**KIRKLEES METROPOLITAN COUNCIL  
INVESTMENT & REGENERATION SERVICE**

**DELEGATED DECISION TO DETERMINE PLANNING APPLICATIONS**

Reference No:	<b>2024/62/90254/W</b>
Site Address:	150, Lockwood Road, Lockwood, Huddersfield, HD1 3QX
Description:	Erection of single storey and first floor extensions to rear, alterations to roof including raising height of the ridge, dormer to rear and associated external alterations
Recommending Officer:	Joanna Rednall

**DECISION – Conditional Full Permission**

PROPOSED GROUND FLOOR PLAN  
1:100

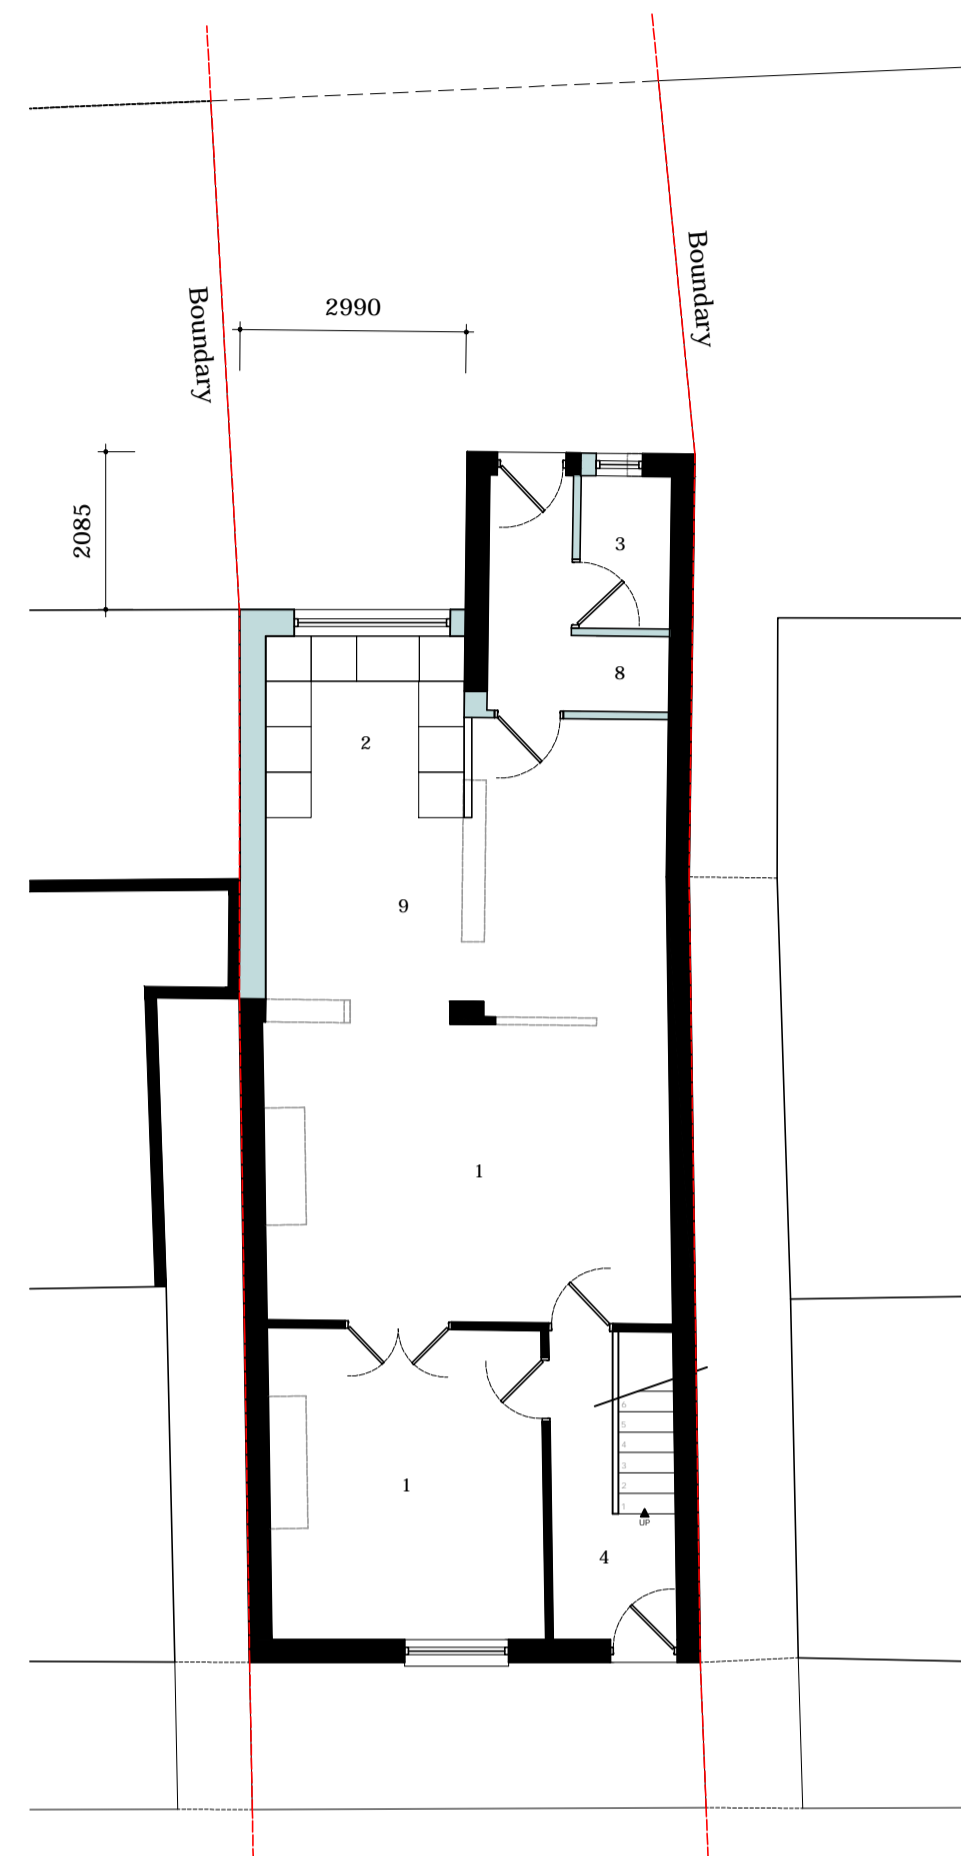
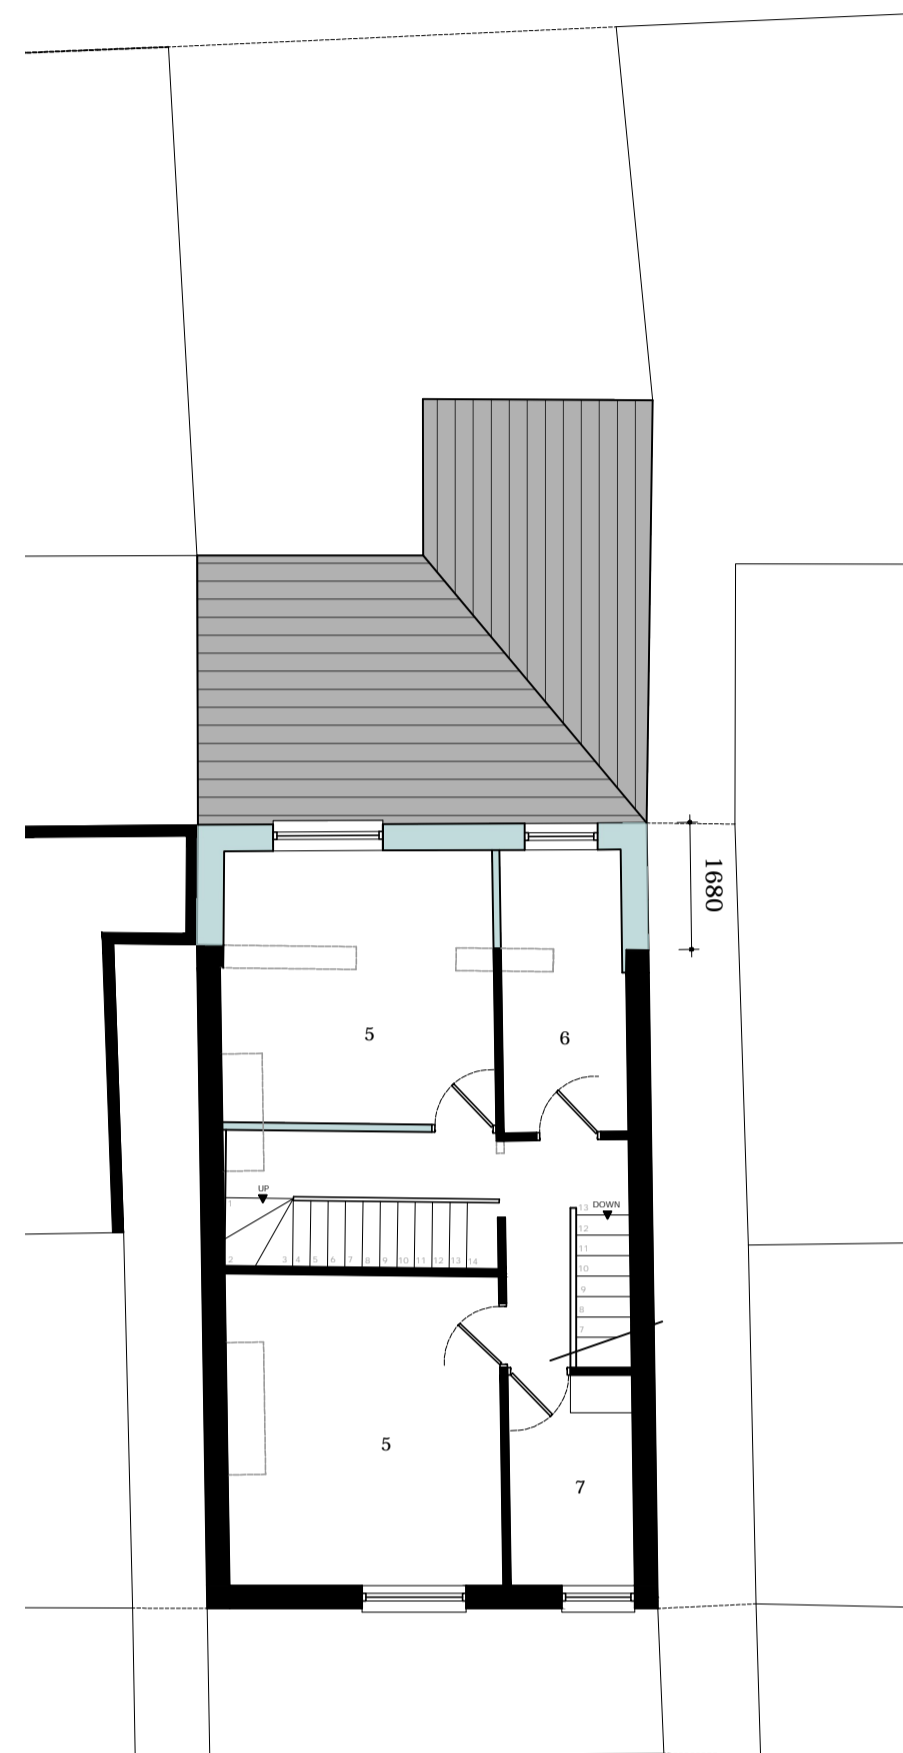
Negotiations were undertaken to reduce the projection of the rear extension and to alter the roof form from a flat roof to a mono pitch to harmonise with the wider street scene.

Although the extension would depart SPD guidance and project more than 3 metres in length, the extension would lie flush with the adjacent single storey extension next door, and other rear extensions along the row (5m in projection). The retention of the narrow outrigger mitigates the impact on the extension from elsewhere as this has a rear projection of approximately 7.2 metres. This would mitigate detrimental harm to the visual amenity and therefore an extension of this size would be acceptable in this case.

This dwelling is adjoined to the application site from the south-west facing elevation. It is noted that these neighbours would originally have been the most impacted by the works proposed. The single storey extension would have extended the existing rear outrigger from the south-facing elevation by 2m. This element has now been removed. (as 152 has a ~5m single storey rear extension).

PROPOSED ROOF PLAN  
1:100

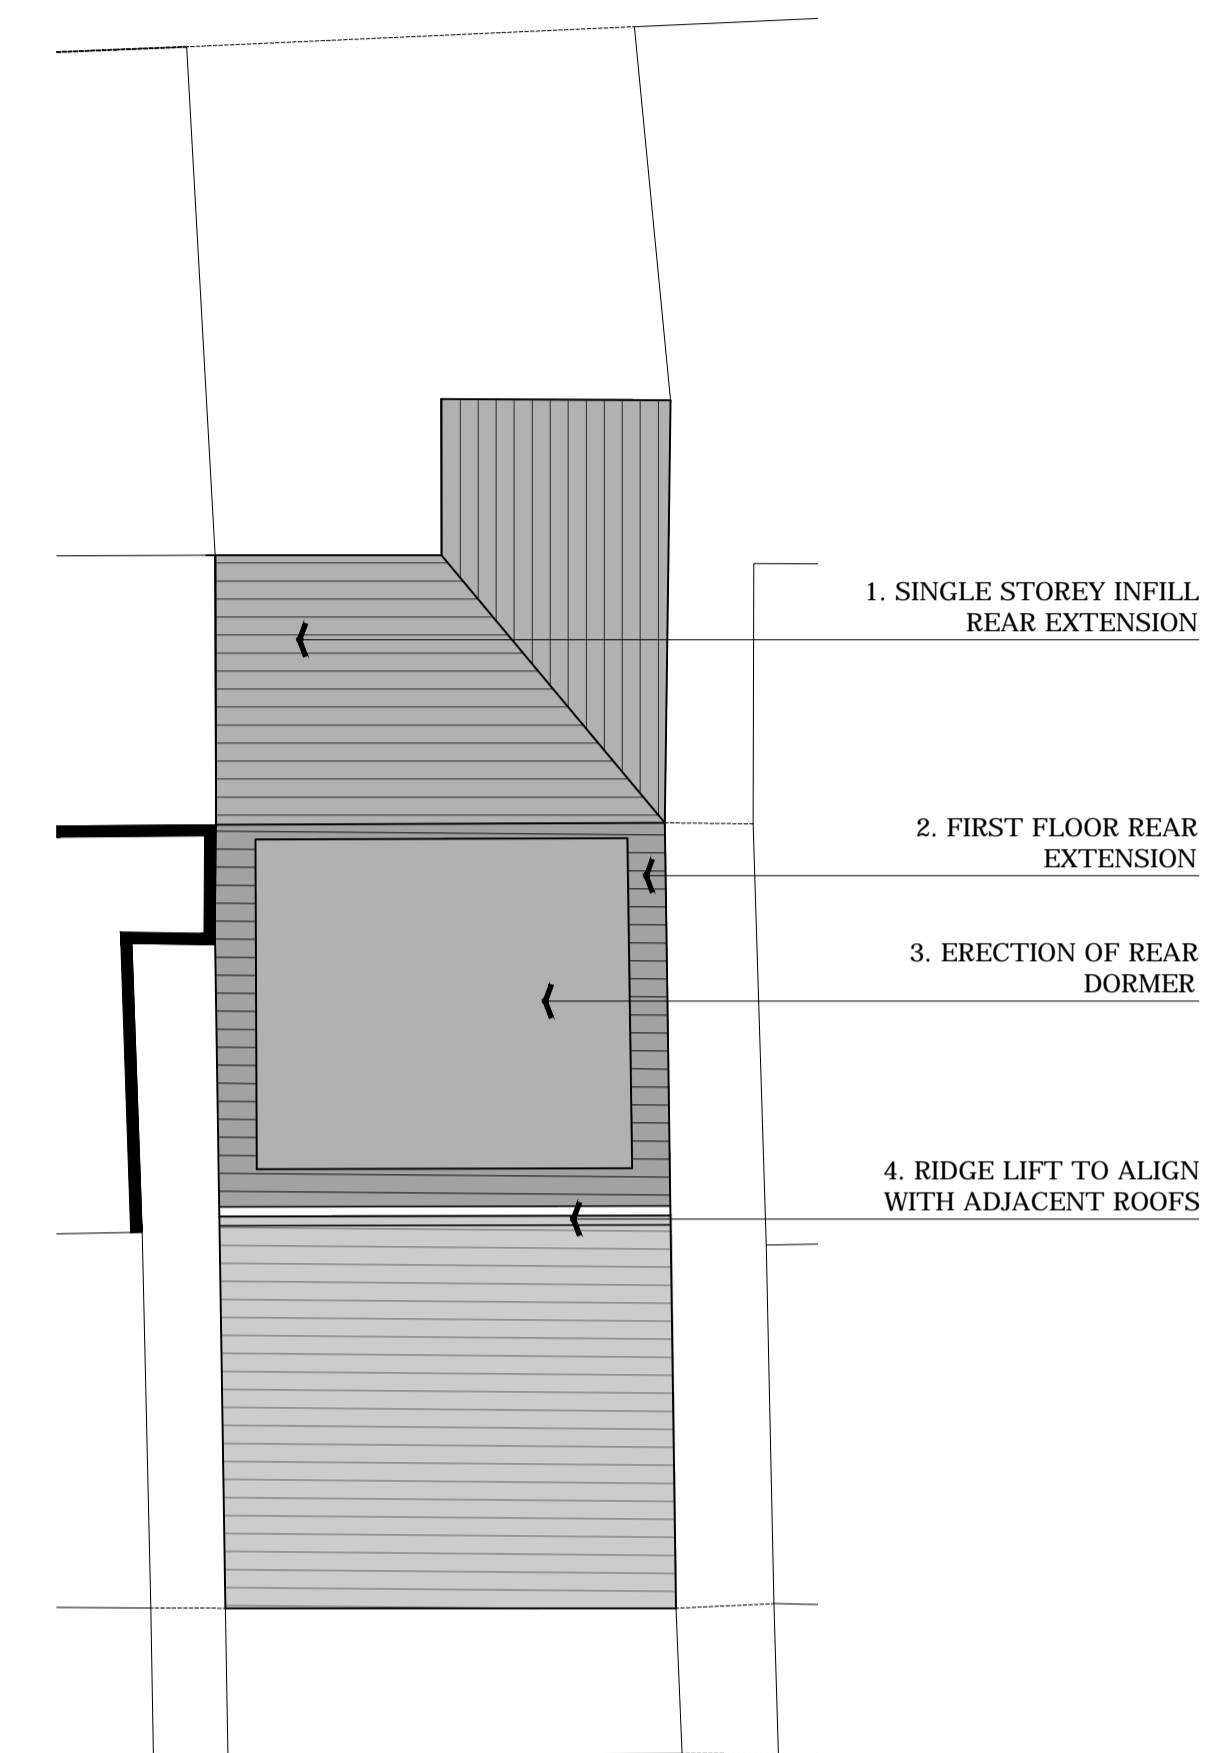
The ridge of the roof would be raised 550mm to match the height of adjoining dwellings and would be constructed from natural slate to match existing.

The roof would be raised ~550mm to align with adjacent roofs as part of the works. This has been considered acceptable from a visual amenity perspective, as the materials and design would be the same as existing. This will ensure that the proposal accords with Policy LP24 of the Local Plan.

PROPOSED REAR ELEVATION  
1:100

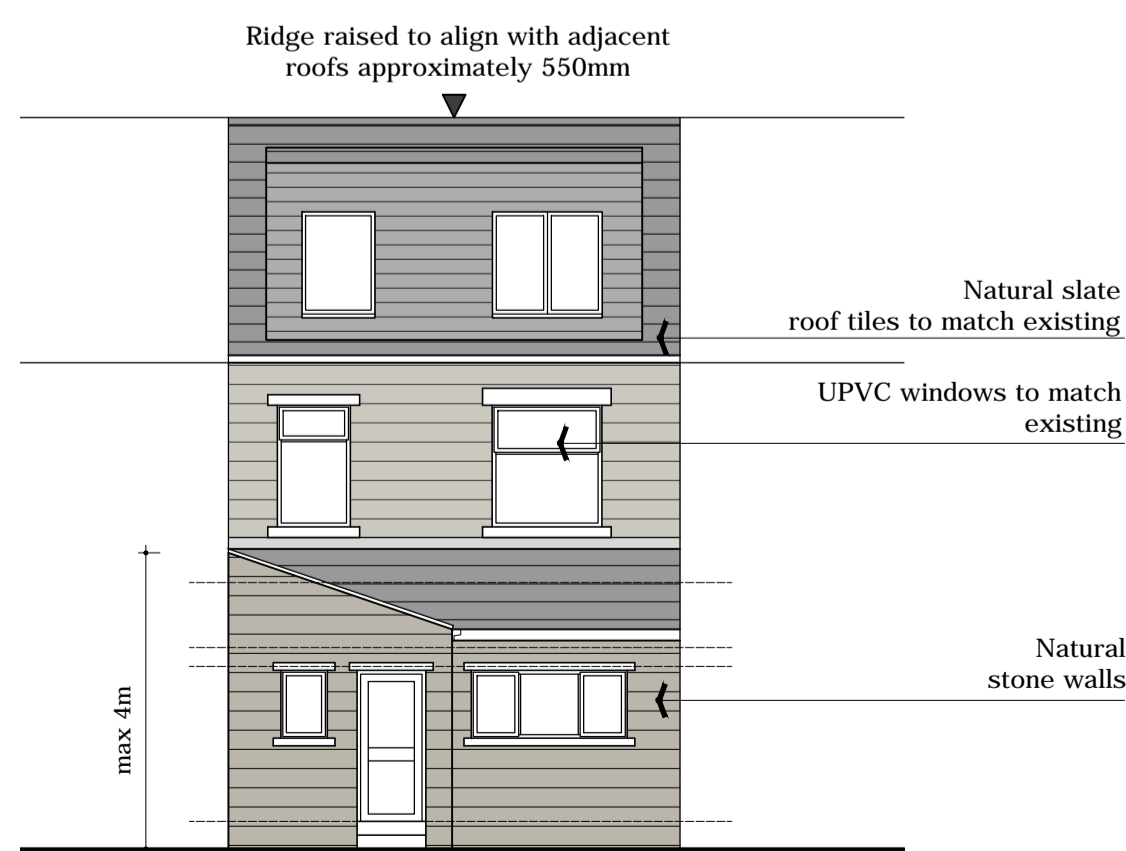
With regard to the first-floor extension, the proposed construction materials would consist of natural stone for the walls with two UPVC windows to match existing. The first floor would project ~1.6 metres from the rear elevation and lie flush with adjoined neighbouring dwellings. The height would increase by ~0.5 metres which is acceptable from a visual perspective, as the eave height of the application property would match that of the adjoined terraces.

The design of the dormer has been considered acceptable from a visual amenity perspective. The dormer would be located to the rear of the dwelling with a rubber flat roof. The walls would be constructed from grey concrete tile cladding, therefore would appropriately relate to the materials of the roof. A sufficient level of roof space would be retained, and the dormer would not project above the new ridge of the house. A site visit confirmed that there is a large rear dormer within the rear roof plane of adjoined dwelling 152, Lockwood Road. Therefore, it is considered that the proposed dormer would

3. The external walls and roofing materials of the extensions hereby approved shall in all respects match those used in the construction of the existing building. The face and cheeks of the rear dormer shall be finished in small grey concrete or natural slate tiles.
